**West Yorkshire Police
Kirklees District**

To: Alice Downham Kirklees Council Planning Services	Ref: 2023/91421 Date: 19 th June 2023
---	---

Site Location: 17 Market Street, Heckmondwike, WF16 0JY

Application type: Change of use and alteration to form a 6 Bed HMO and retail unit

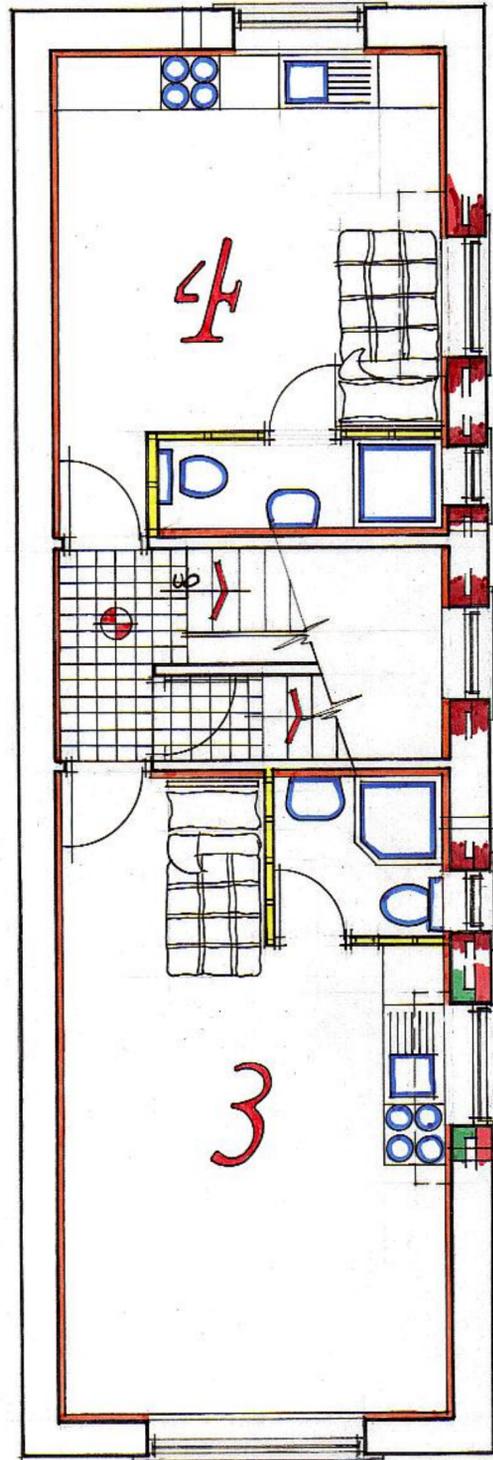
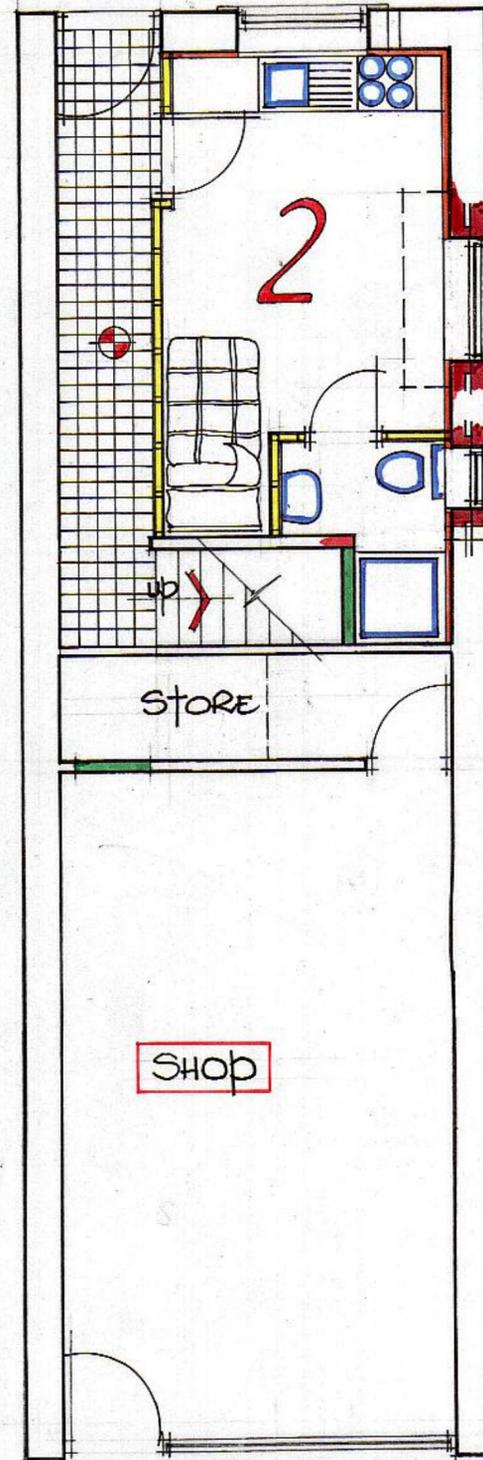
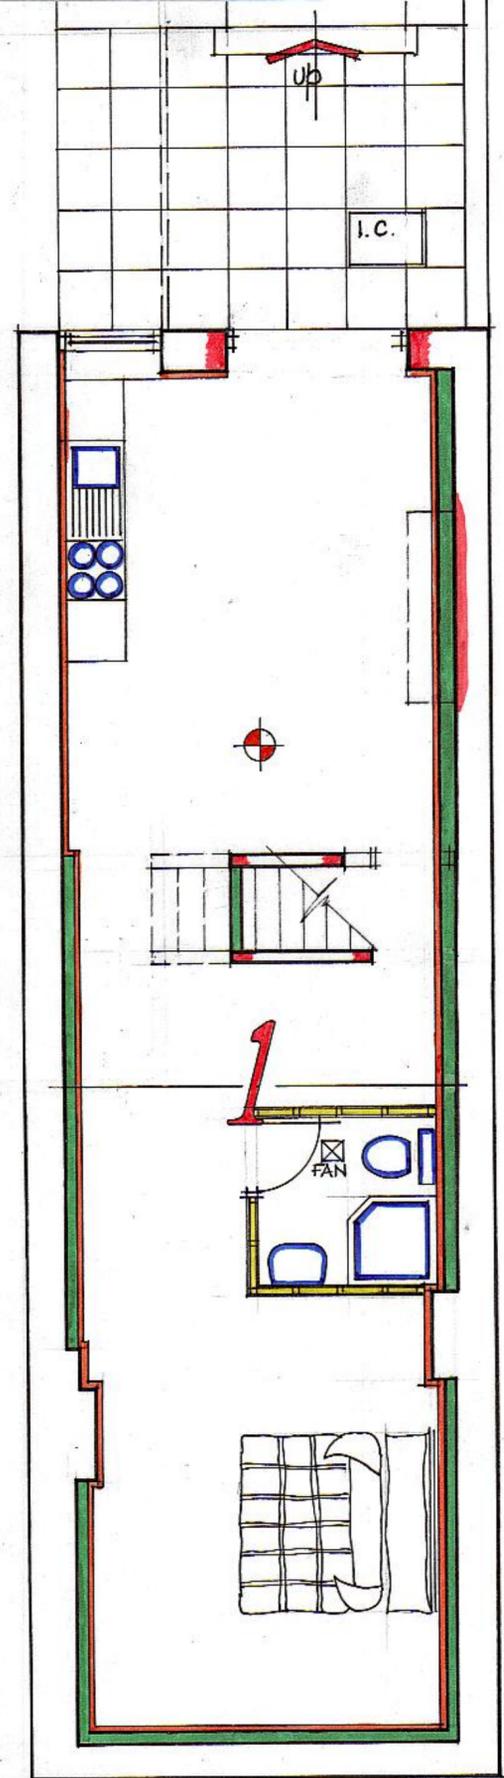
Internal partition wall construction - Details of the wall construction between the individual flats and communal corridors are required. Timber frame with plasterboard covering is NOT recommended due to the ease of access by offenders. Please see the below advice.

Dividing walls between internal dwellings must be to STS 202 Issue 7 BR1 standard or made from solid materials such as concrete block or brick. Any internal partition wall made up from non-solid material such as plasterboard and wooden studwork should be reviewed for security purposes.
